Our Ref: F/30/17/HH
Your Ref:

Town & Country Planning Act 1990 (as amended)
Town & country Planning (Development Management Procedure) (England) Order 2015
Application for Planning Permission for Works or Extension to a Dwelling

Development Conservatory to rear
Location 2 Arunford Close Ford

EXISTING LEFT ELEVATION

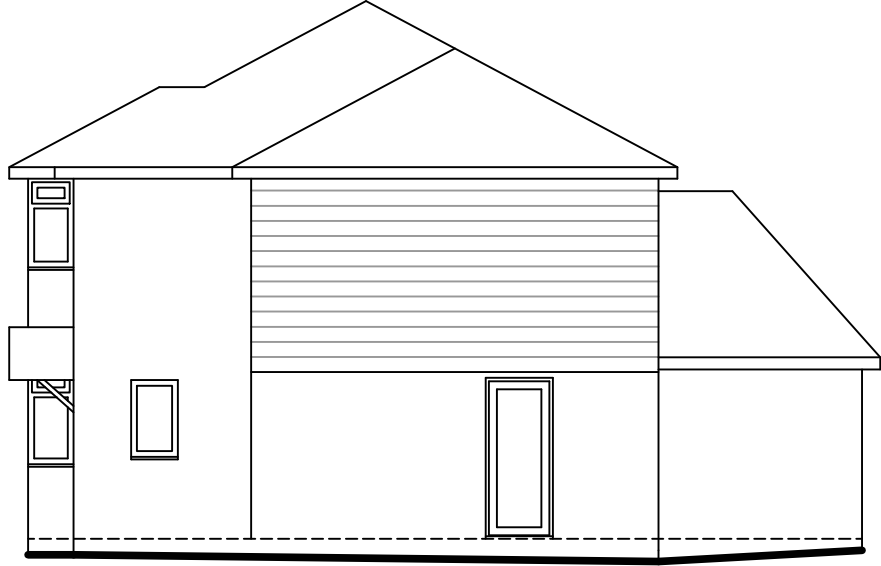
The existing and proposed left elevations and floor plans do not accord. Please amend accordingly.
